**Re: CDS21008079 pre-connection enquiry - Subject to contract | Contract denied**

**Connection for Housing Development of 550 unit(s) at Ravens Rock Road, Sandyford, Dublin**

TITLE PROPOSED FOUL & SURFACE WATER DRAINAGE OUTFALLS

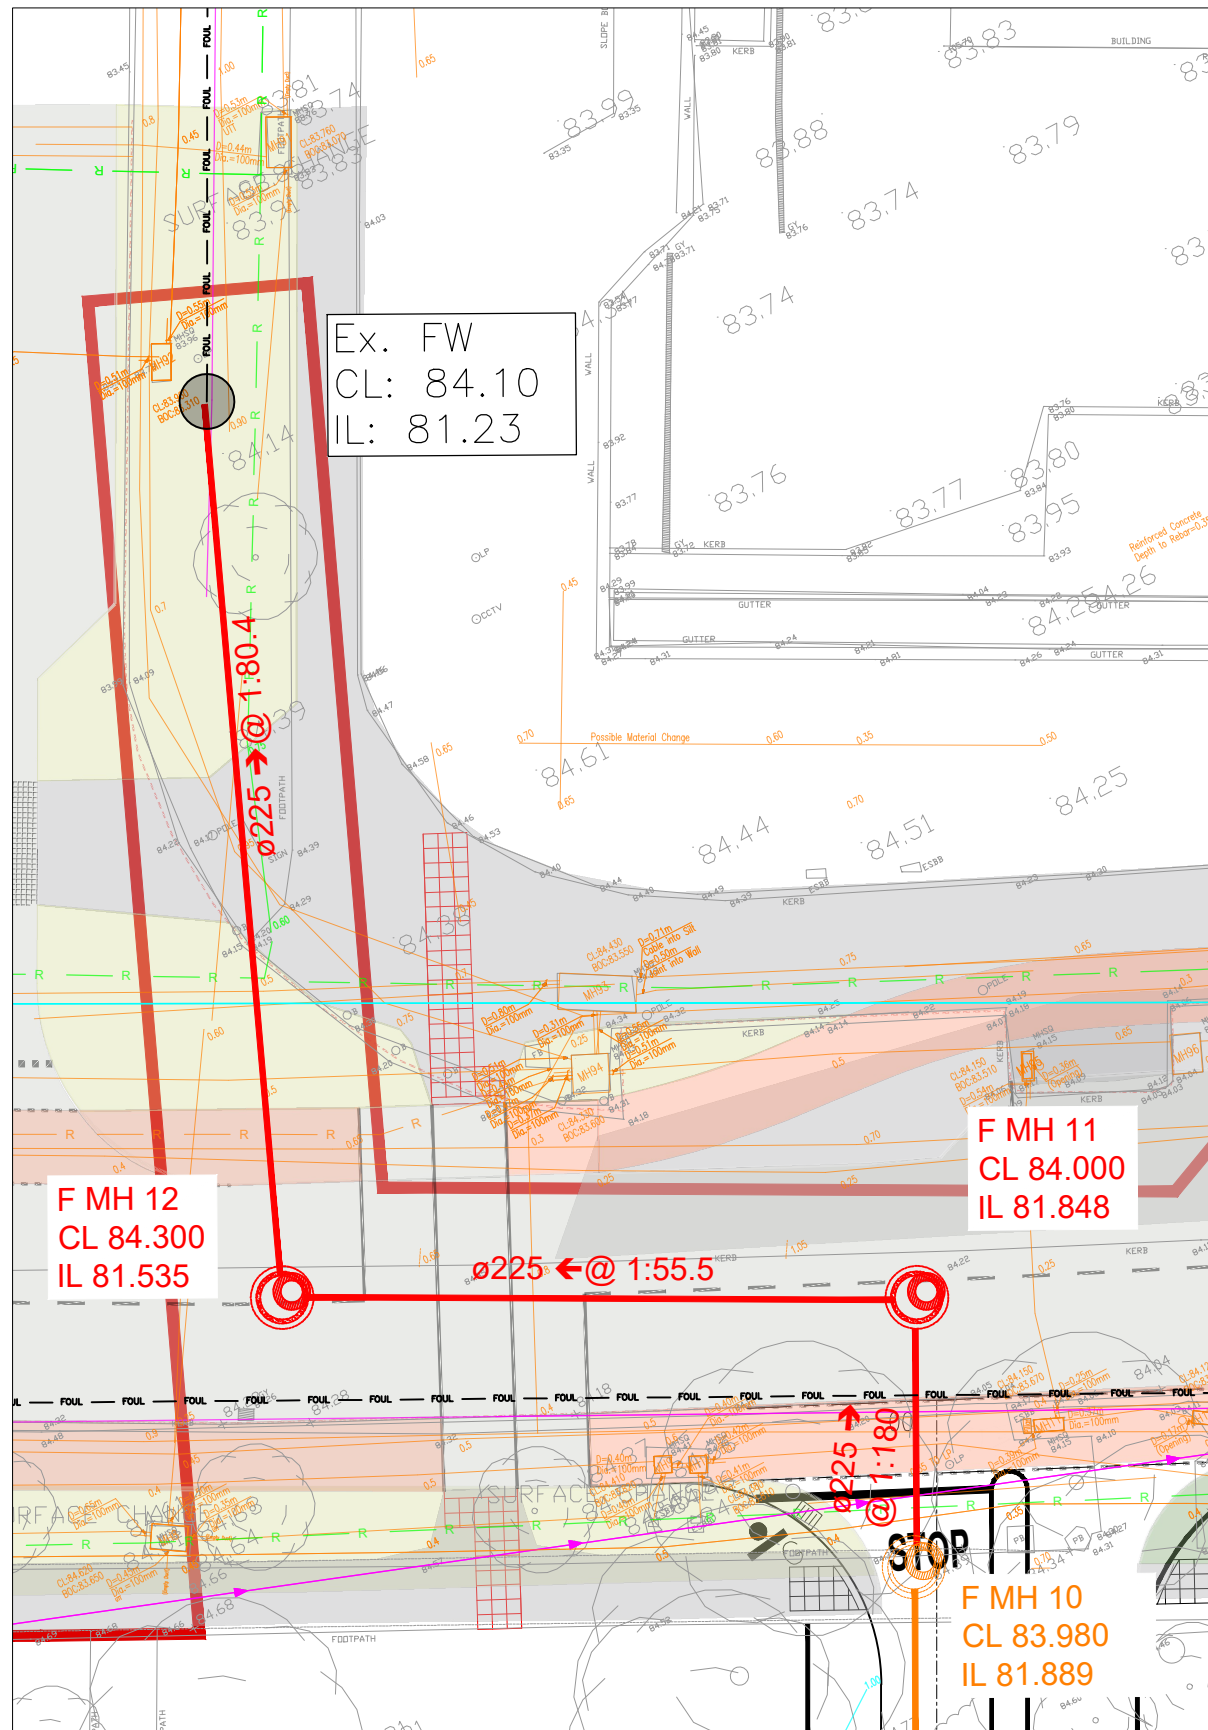
Separate storm and foul water connection services have to be provided for the Development. The surface and storm water from the site must be discharged only into an existing storm water network that does not discharge to an IW combined/foul sewer. The connection arrangement should be agreed with the Local Authority Drainage Division.

The connection has to be made to the Arkle Road (MH: SO19264601) network as shown below. A second connection to other sewers adjacent to the site are not feasible based on current constraints in the downstream network.
